City of Albuquerque Stormwater Construction Site Inspection Report

ESC File No.	K09E048D	Project Name:	Caliber Collision		
NPDES Id. No.	NMRT00607 & 08	Location:	250 98th St NW		
10/21/2024	Owner		Contractor		
Operator	Cross Development CC Albuquerque, LLC		Madewell Construction		
Contact name & title	Joe Dell		Paul Hubbard		
e-mail	<a href="mailto:Joe@crossdevelopment.net">Joe@crossdevelopment.net</a>		<a href="mailto:paul@madewell-construction.com">paul@madewell-construction.com</a>		
Contact Phone #	214-762-1824		937-798-1475		
COA Inspector	Doug Hughes		Time	9AM	
Construction Phase:	Plumbing & footers				
Type of Inspection:	Regular	Storm Event	Post Storm Event >0.25"	311/Complaint	Follow Up
Weather at time of inspection?	Temperature: ~			50	
Estimated date of last storm 0.25" or greater	10/19/2029

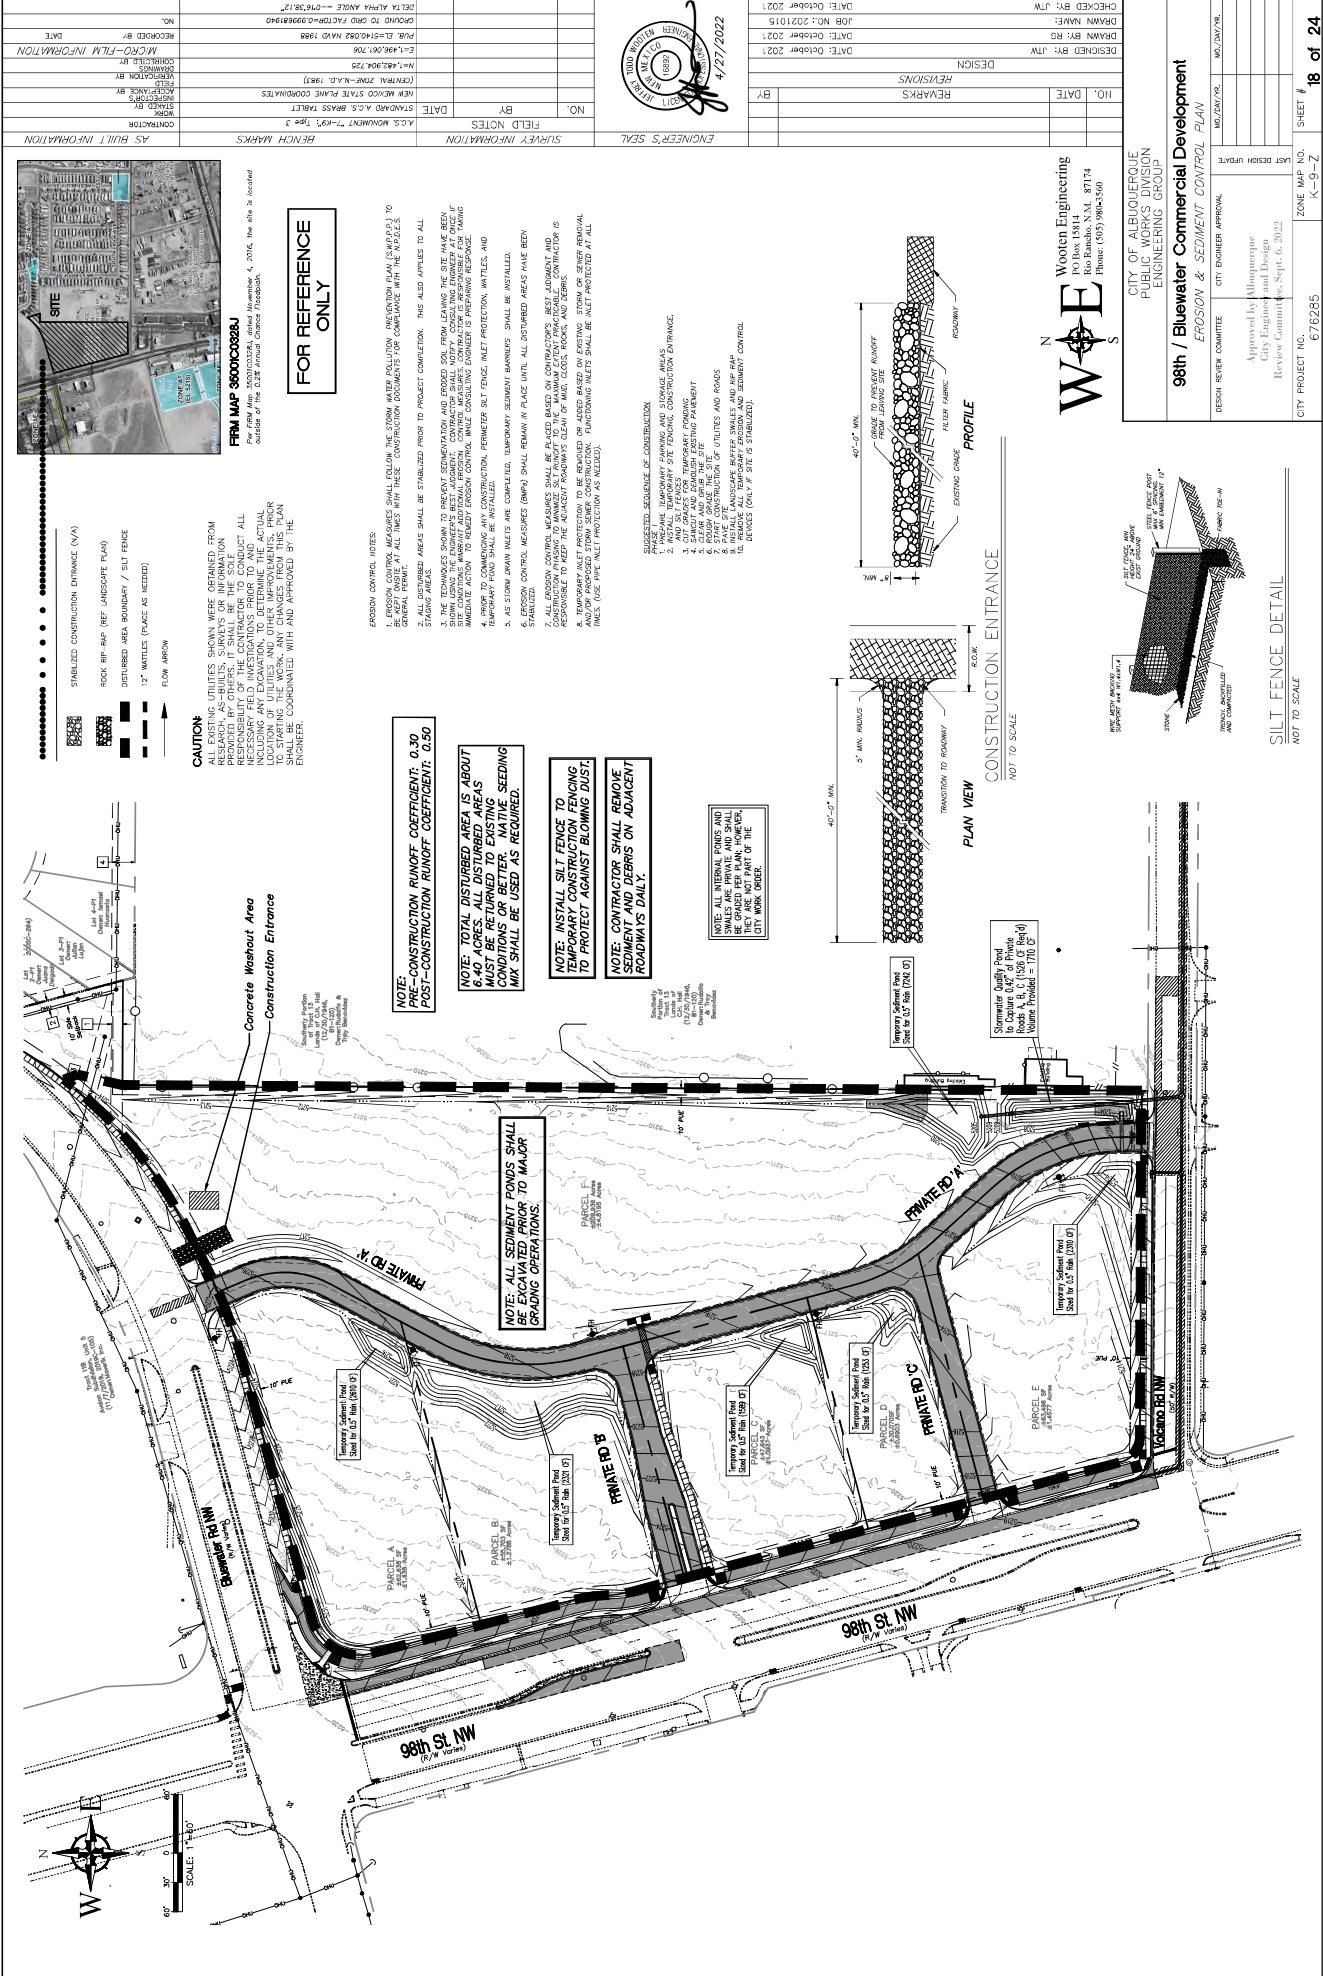
Item Number	Deficiency/ Corrective Action				
1	<p><b>Stabilization</b>— The south half-acre is inactive and not properly stabilized in violation of CGP 2.2.14. Weeds in that area are in violation of the Weed, Litter, and Snow Removal Ordinance (§ 9-8-1). <b>Required Mitigation:</b> Stabilize the inactive disturbed areas and “large bare areas” per CGP 2.2.14.c.i. Implement and maintain stabilization measures in areas that remain inactive for 14 days or more. Measures must be initiated within 14 days and completed no later than 14 days per CGP 2.2.14.</p>				
2	<p><b>BMPs</b> - The Silt Fence was missing around the south half acre of the site in violation of CGP 2.1. Earthwork had blocked the temporary diversion swale on the east side of the property last month. Some dirt had been removed, but the swale was still blocked, and there were several holes in the silt fence. The potential diversion into the neighbor's property creates a new erosive discharge point to the east violating CGP 2.2.11. The west silt fence also has several holes in it. The new stormwater pond was supposed to be constructed before the earthwork began, but it is still incomplete in violation of CGP 2.1.3. <b>Required mitigation:</b> If at any time you find that a stormwater control needs routine Maintenance, you must immediately initiate the needed maintenance work and complete such work by the close of the next business day. When the problem requires a new or replacement control or significant repair, install the new or modified control and make it operational or complete the repair by no later than seven (7) calendar days from the time of discovery per CGP 5.2.1. Portions of the silt fence must be replaced and the east swale restored to grade. All BMPs must be constructed as shown on the approved SWPPP including the stormwater pond.</p>
